Harnett County

Permit Number: BCOM2603-0006

Description: **Hispanic Snack Convention Bar**

LIST OF REVIEWS

LA COSECHA SNACKS
 161 S McKinley Street, Coats, NC 27521

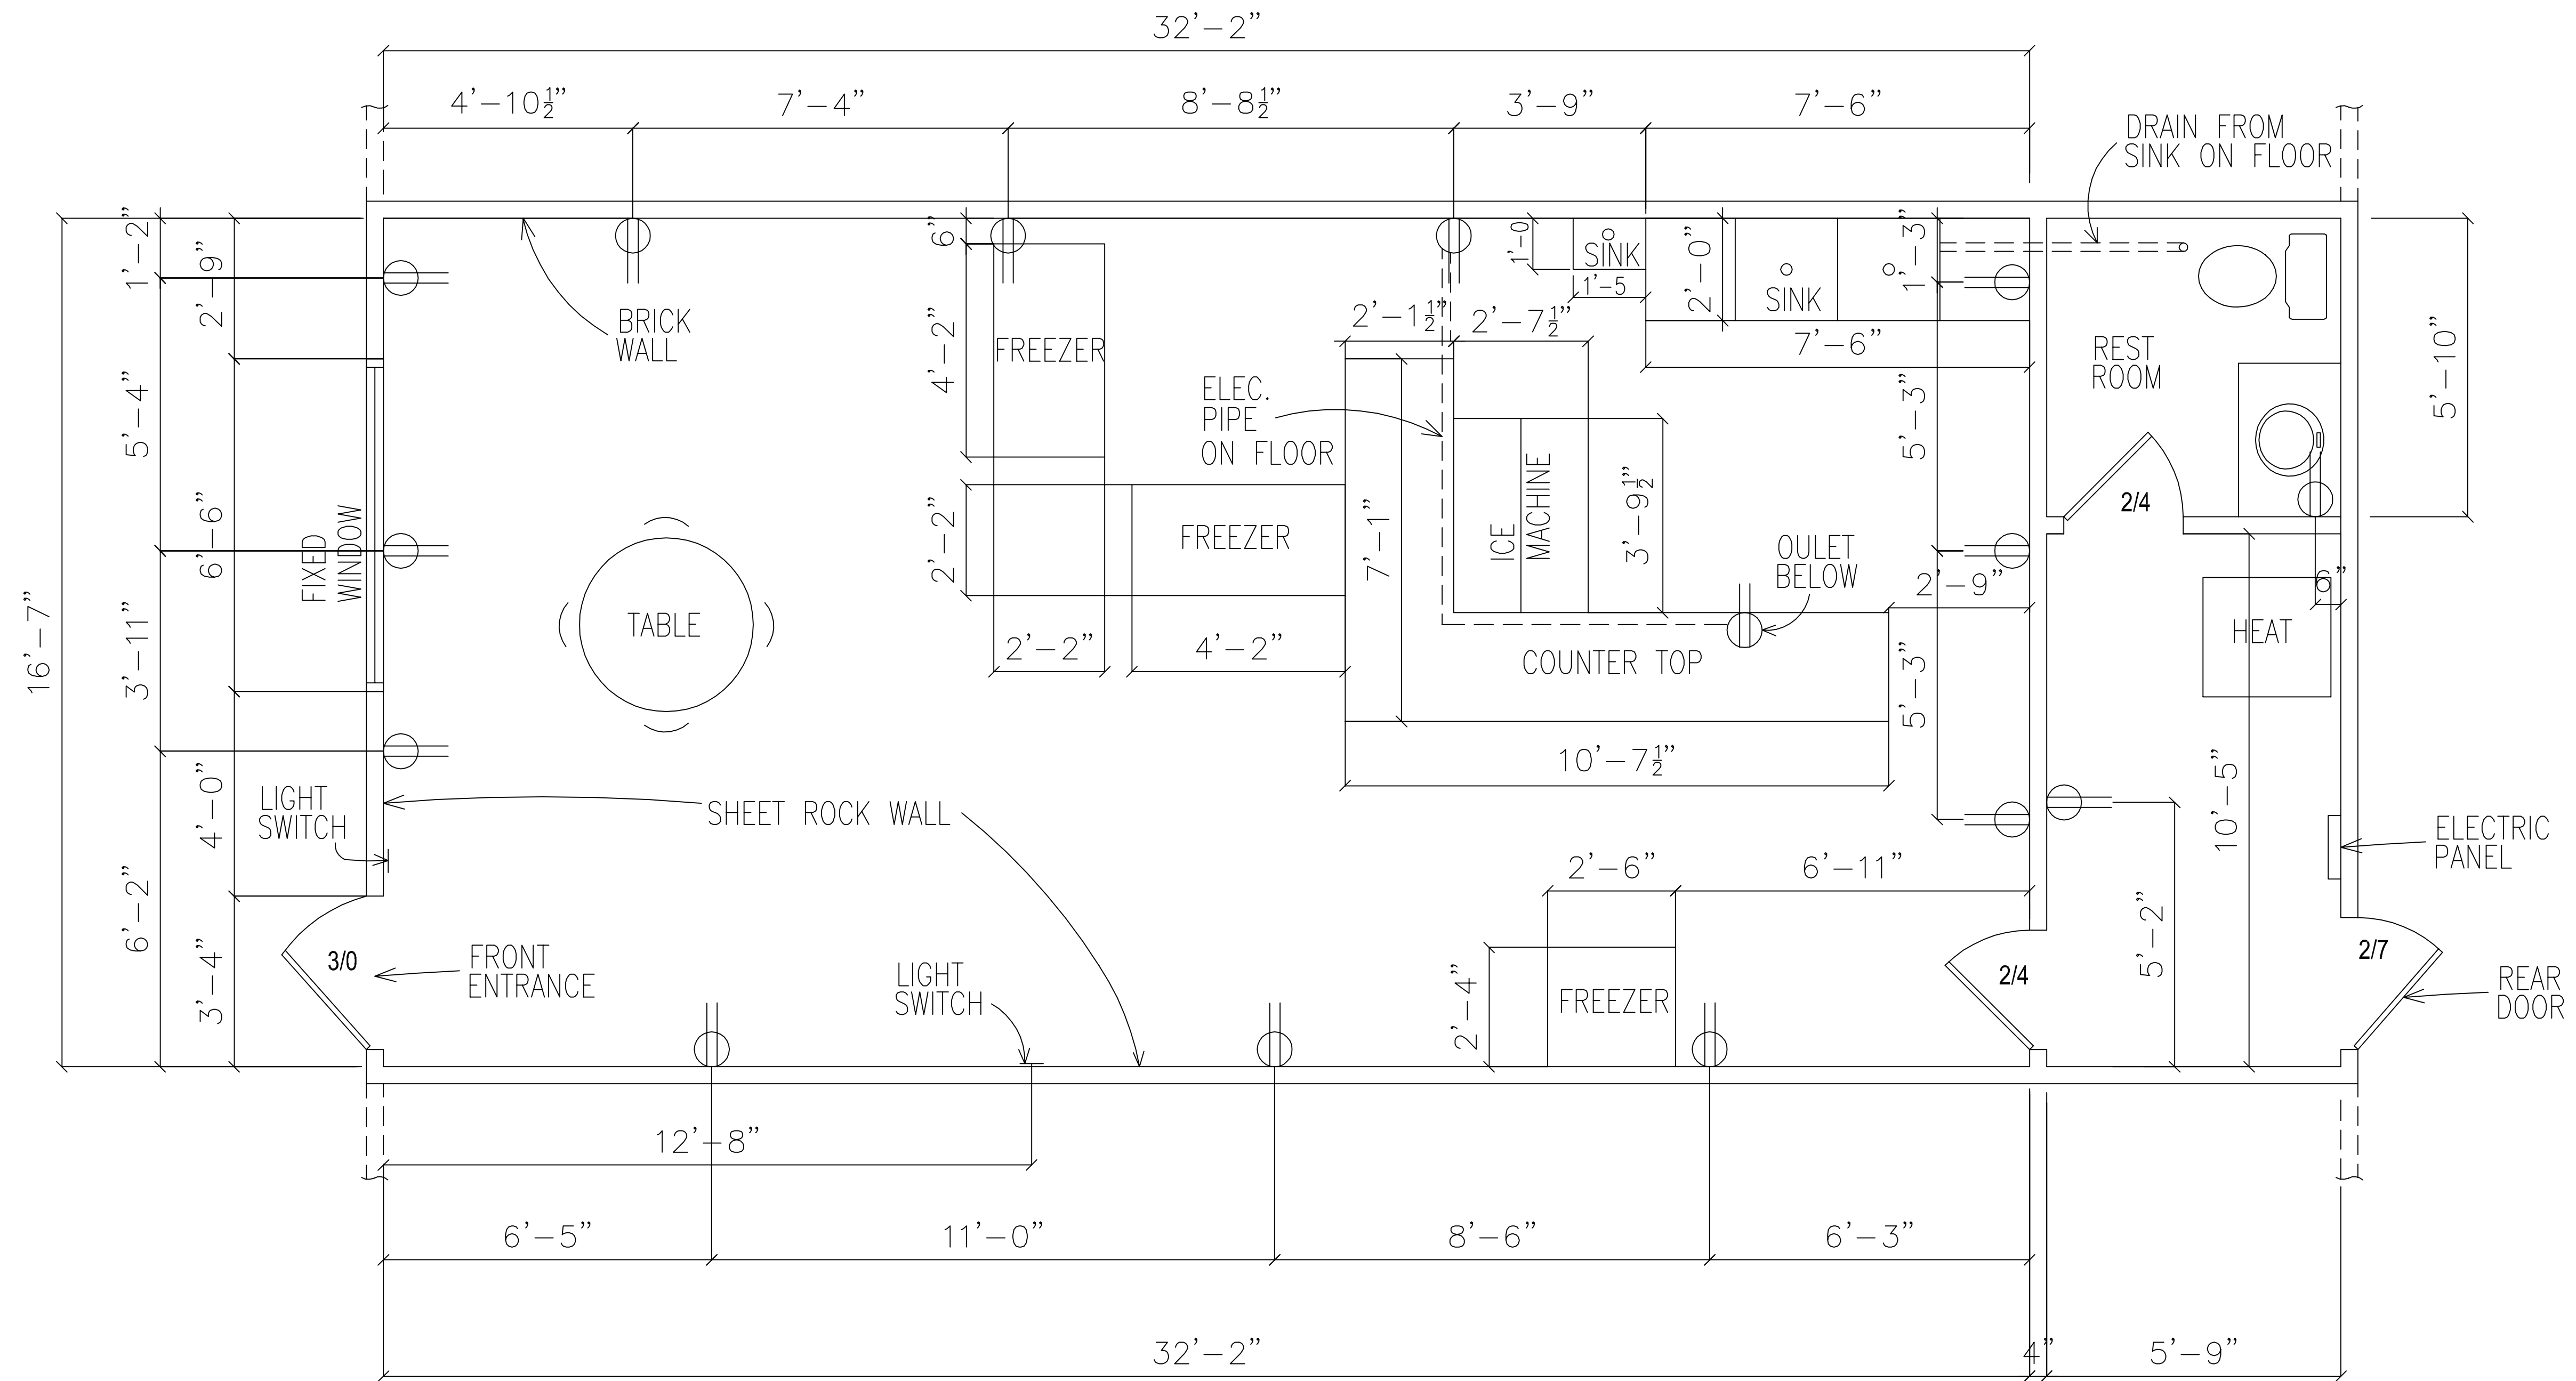
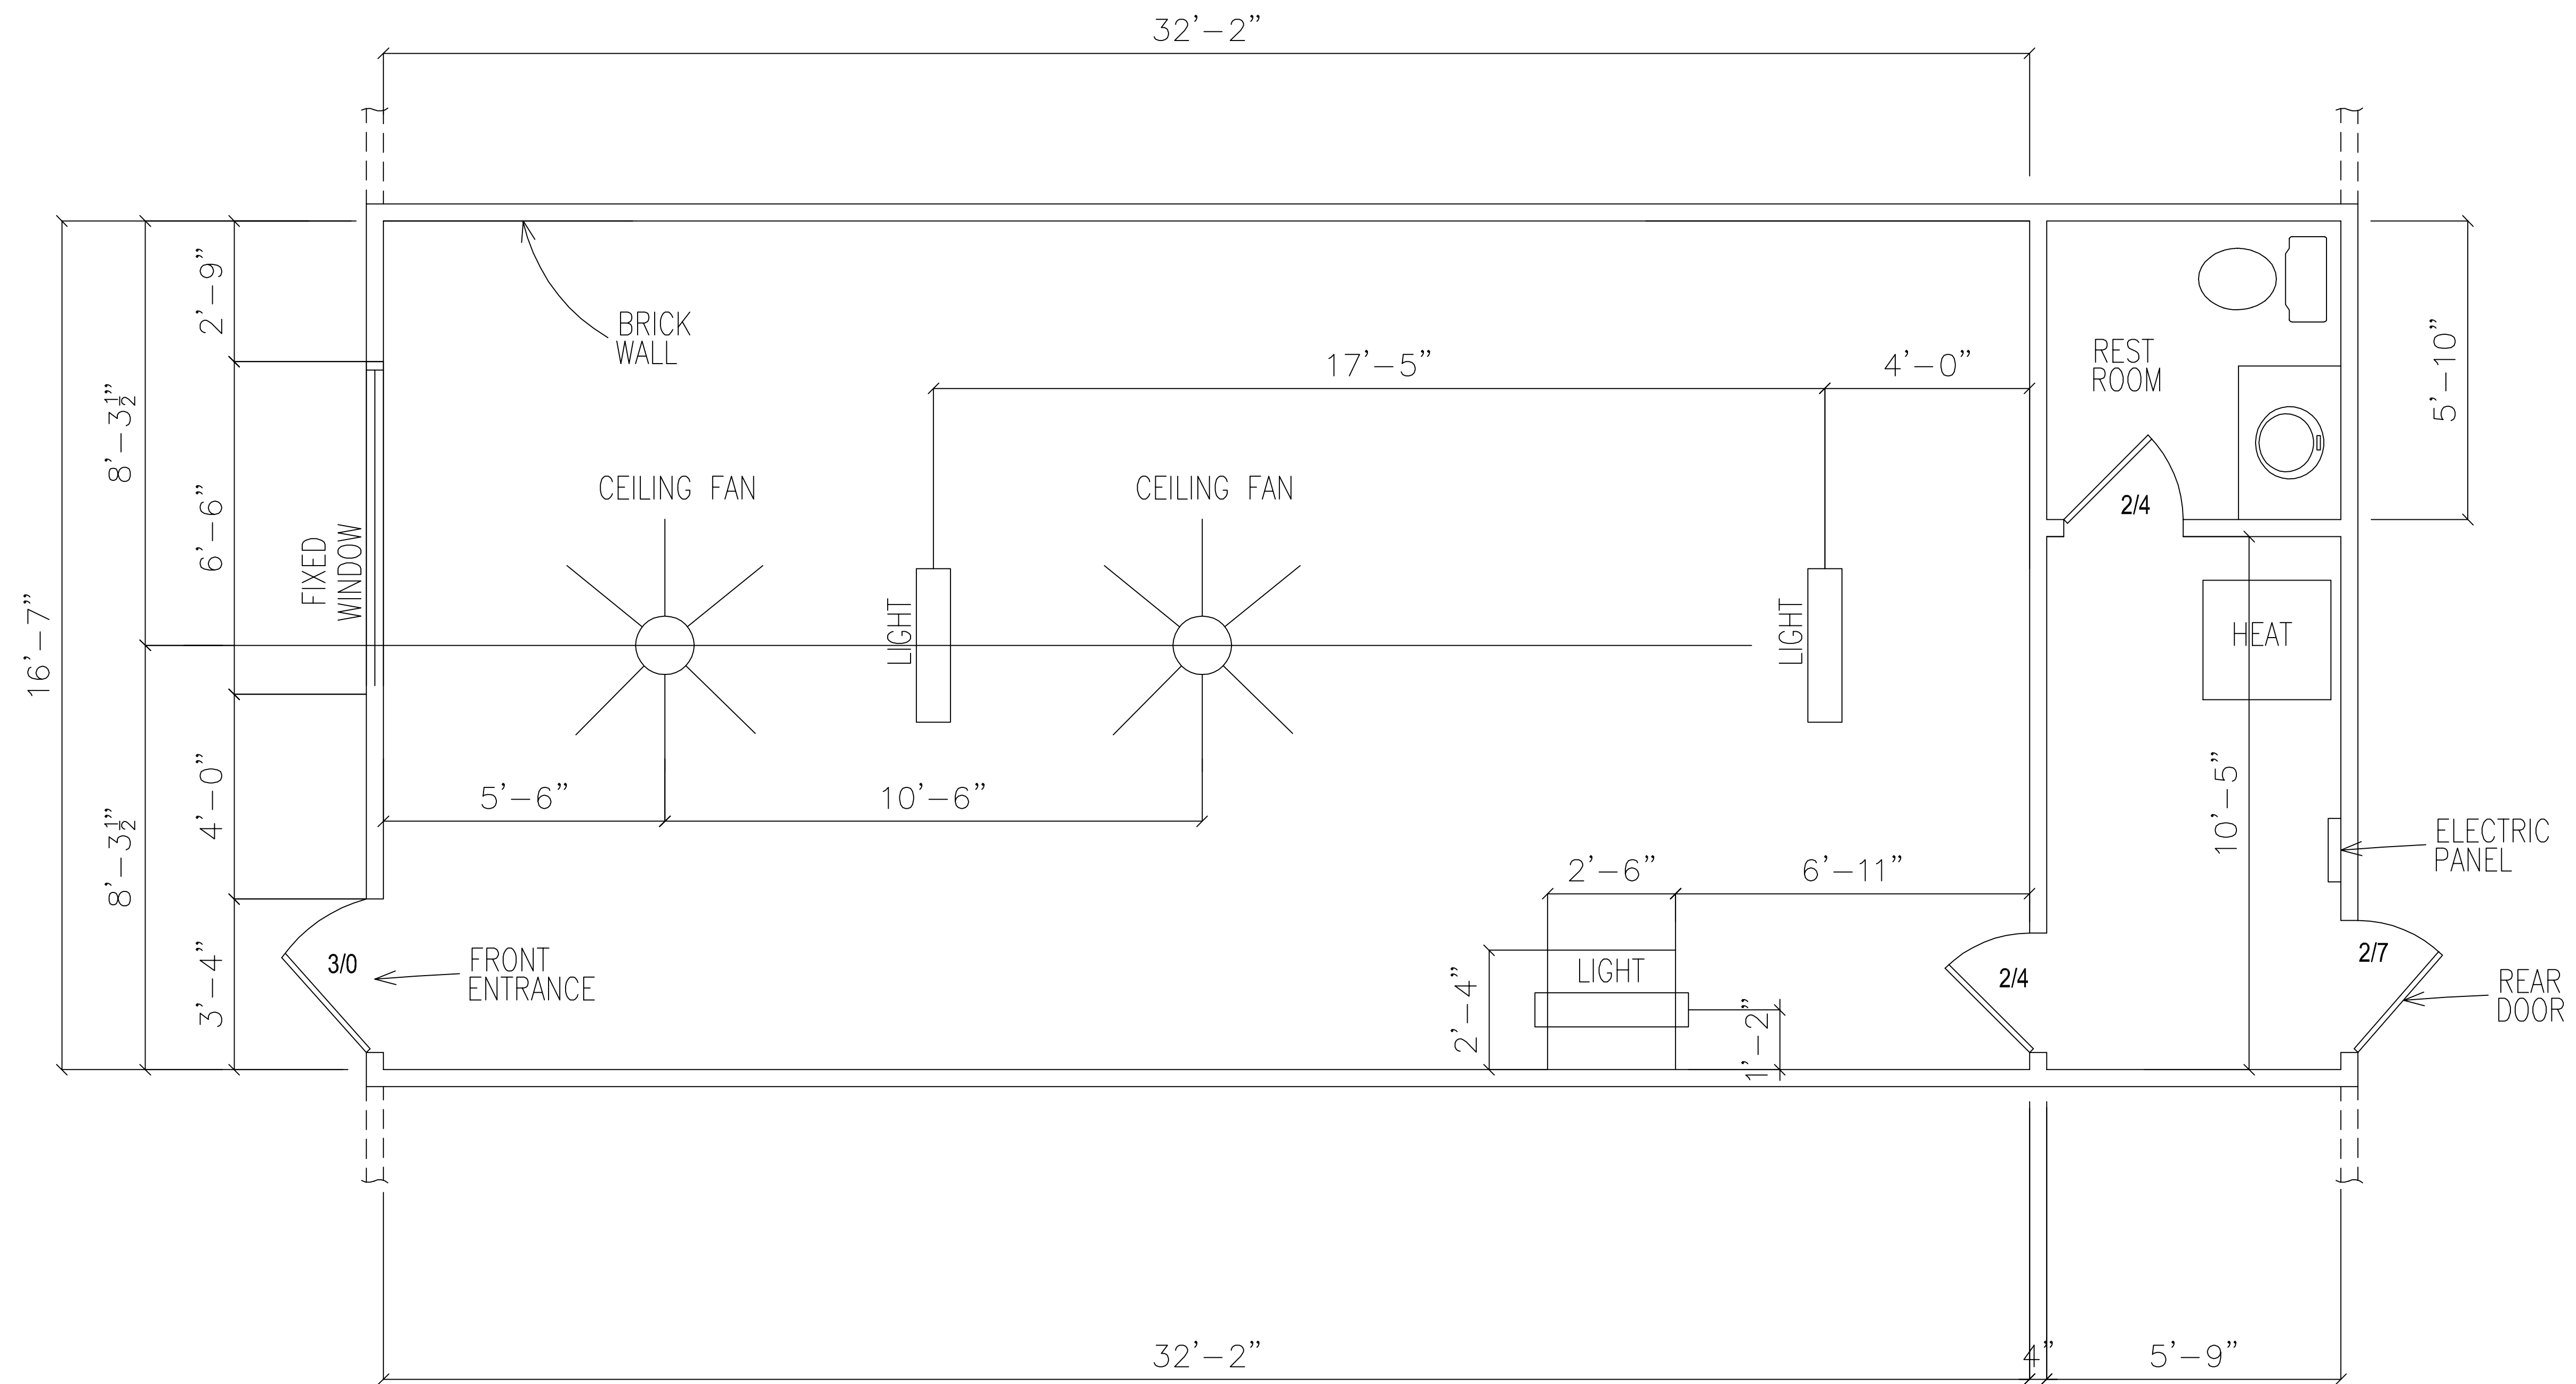
- Life safety plan, fire extinguishers, emergency and exit lighting.						
- Cooking hood plans if any cooking or frying will be done.						
3/25/2026	4/9/2026	4/9/2026	PUBLIC UTILITY	Public Works	DISAPPROVED	
Notes:						
-No cooking or frying will take place; fruit will be cleaned & cut up.						
Outside grease trap is required.						
4/7/2026		4/21/2026	HEALTH AND SANITATION	EH Bucket		
Notes:						
4/7/2026		4/21/2026	FIRE MARSHAL	Fire Bucket		
Notes:						
-Customer confirmed that exit signs & lighting are above exits on new life safety plan/site plan. Fire extinguisher is shown on new plan.						
-No cooking or frying will take place; fruit will be cleaned & cut up.						
Review Group: AUTO						
3/25/2026	4/7/2026		COMMERCIAL INTAKE	CP Bucket	APPROVED	
Notes:						
3/25/2026	4/1/2026	4/9/2026	COMMERCIAL BUILDING REVIEW	Brad Sutton	DISAPPROVED	
Notes:						
Need a scaled plan						
Need food details. Cooking? Prepackaged? If cooking, provide hood and cooking equipment details

Notes:
Customer submitted new life safety plan/site plan.
No cooking or frying will take place; fruit will be cleaned & cut up.
